Re Planning Application 20/01933/F

Planning application 20/01933/F Comment from Wigginton Parish Council

**CLADDING FOR THE WINGS:**

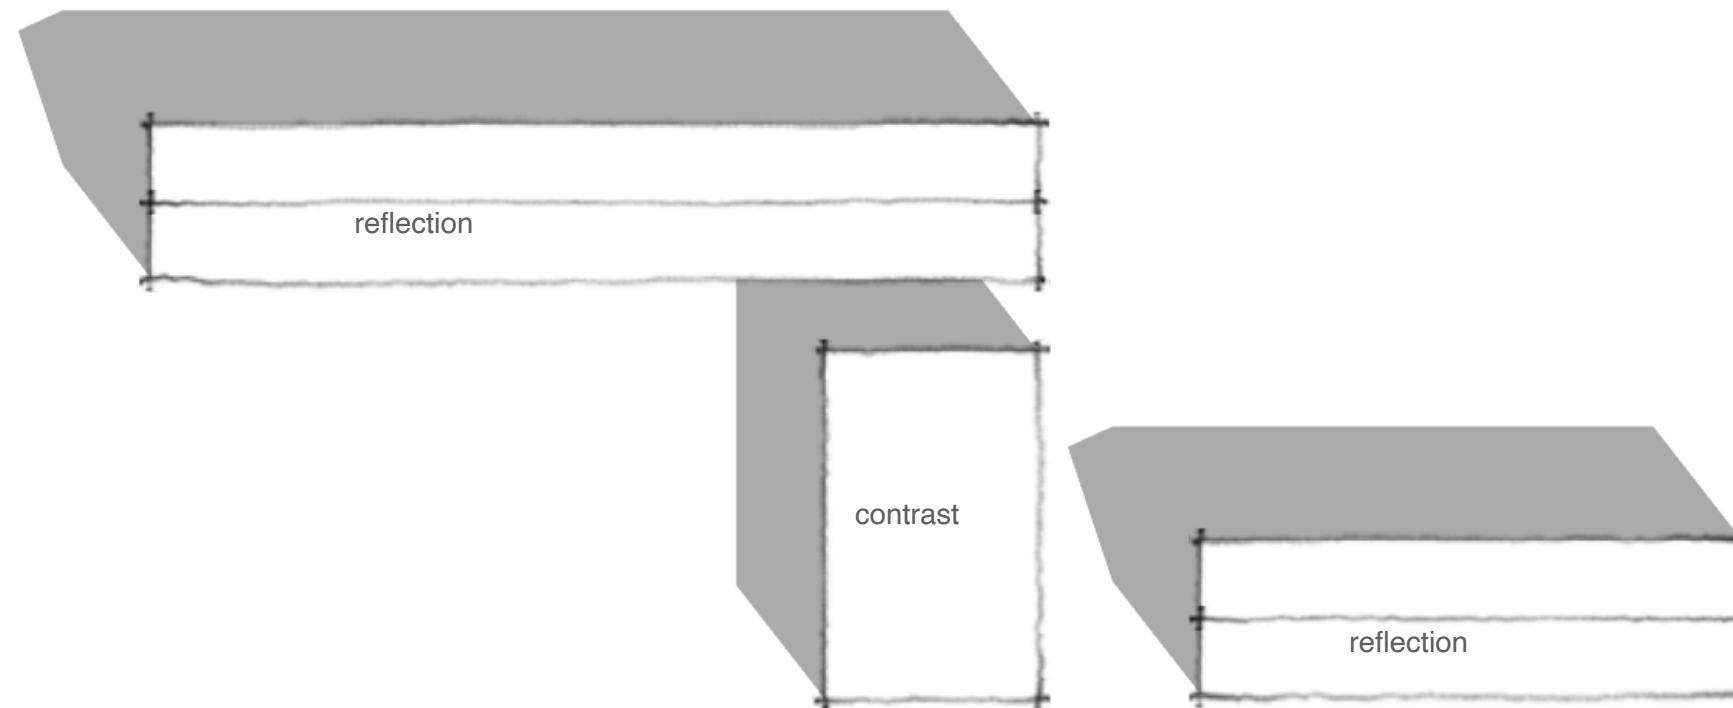
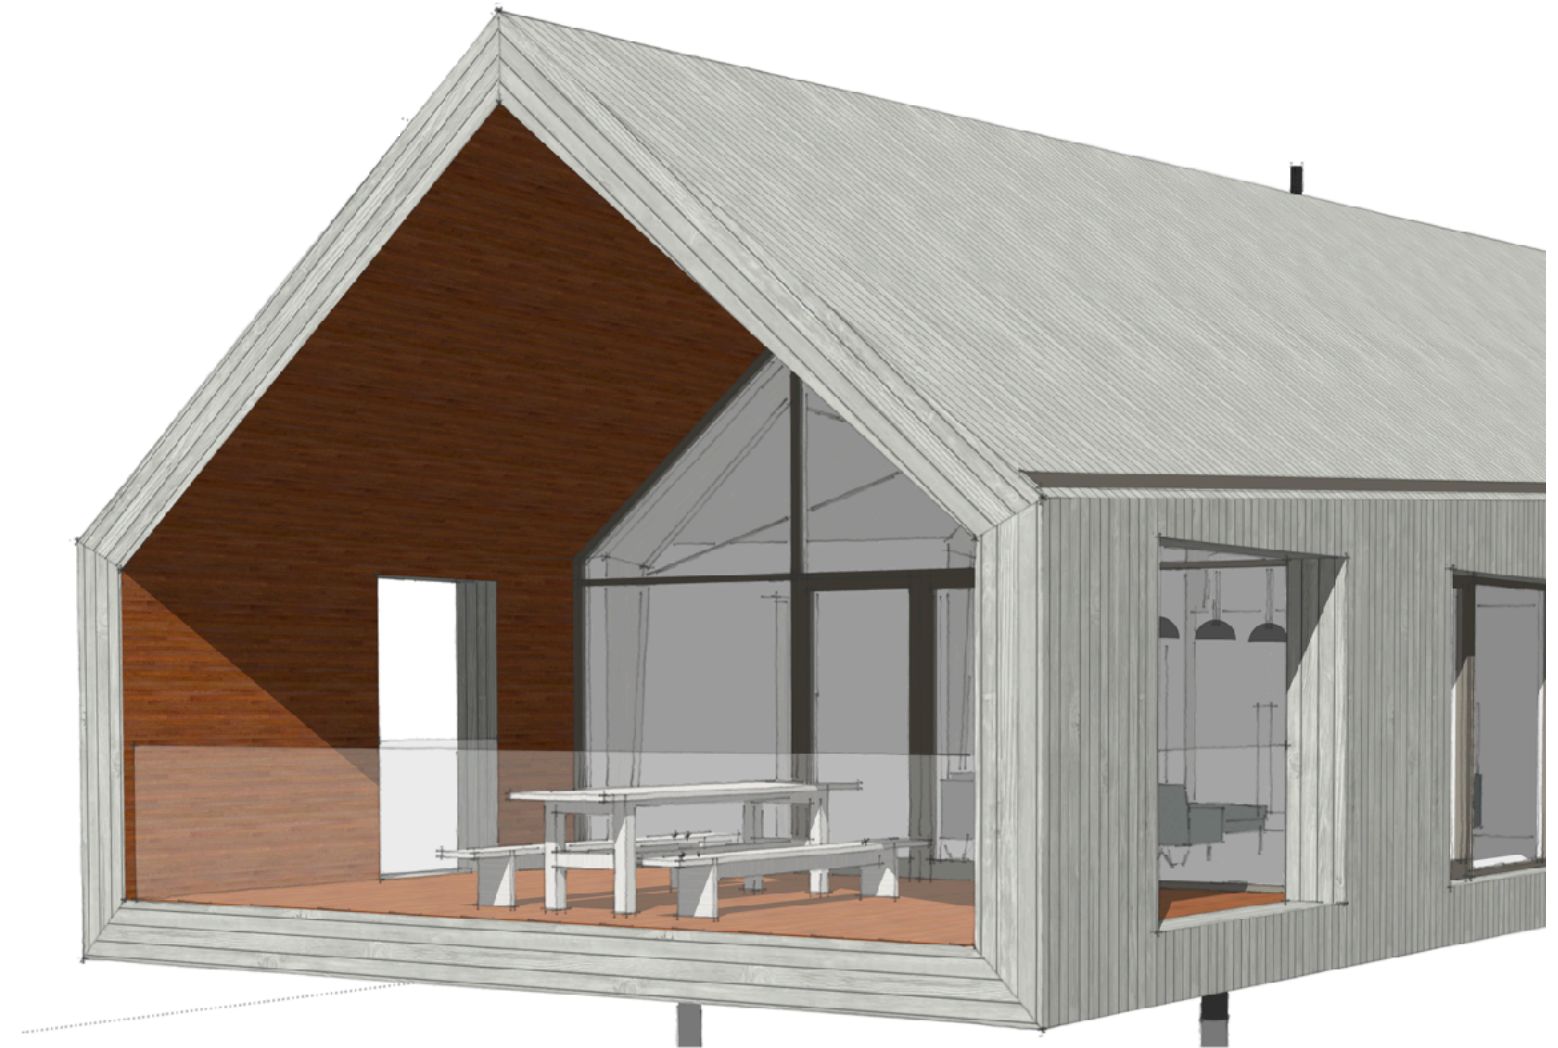
A Para 79 house should raise the standard of design and be sensitive to the defining characteristics of the area. There are several new houses in the immediate vicinity which fulfil these criteria but this is not one of them. Cherwell Policy ESD 16 demands respect for the area's context. No one can doubt that ironstone buildings built in locally quarried Hornton stone are an integral part of this landscape and red cedar cladding is alien.

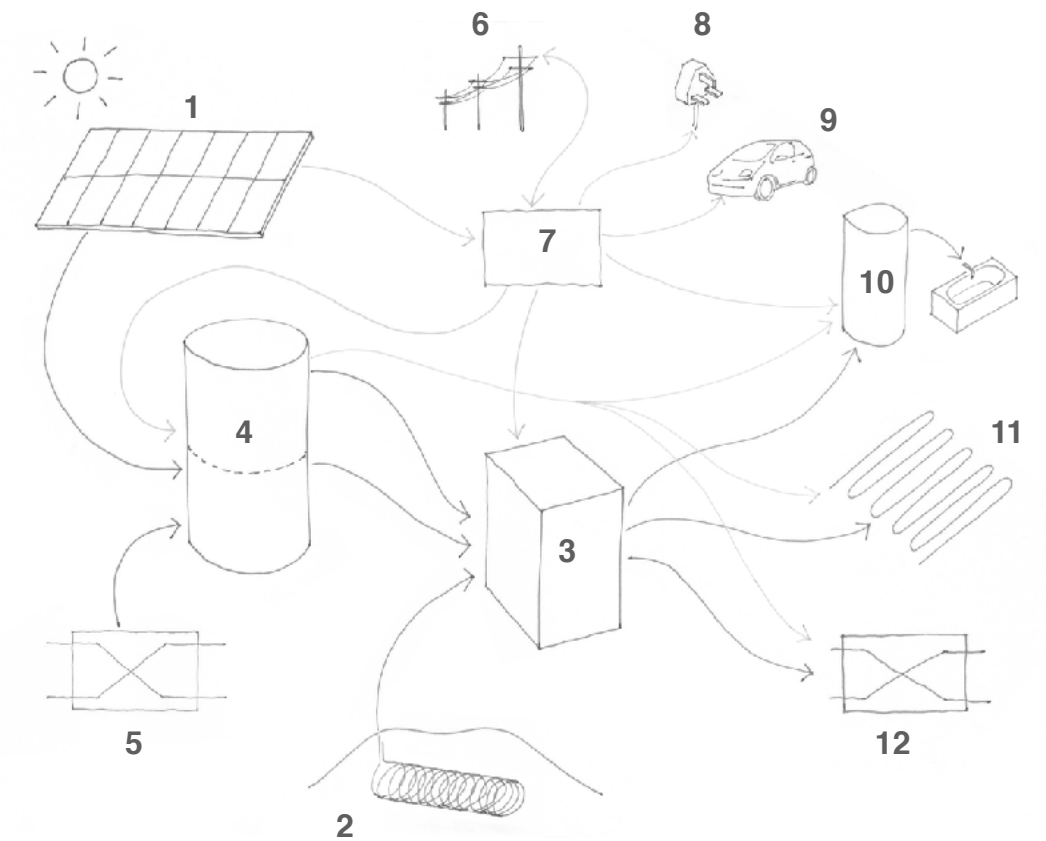
Amongst the copious detailed plans there is scant regard for how the provision of domestic services might affect the local environment. Despite the innovative proposal for heating only fleeting mention is made of the need to be attached to the National Grid and pylons are indicated in a very small diagram on p39 of the Heating Power & Ventilation Strategy.

The architect says we must consider this application as a holistic approach then completely ignores the provision of domestic water, provides a passing comment on the need to join the National Grid and gives no information about the disposal of foul water other than needing a treatment plant somewhere. This is disingenuous to say the least.
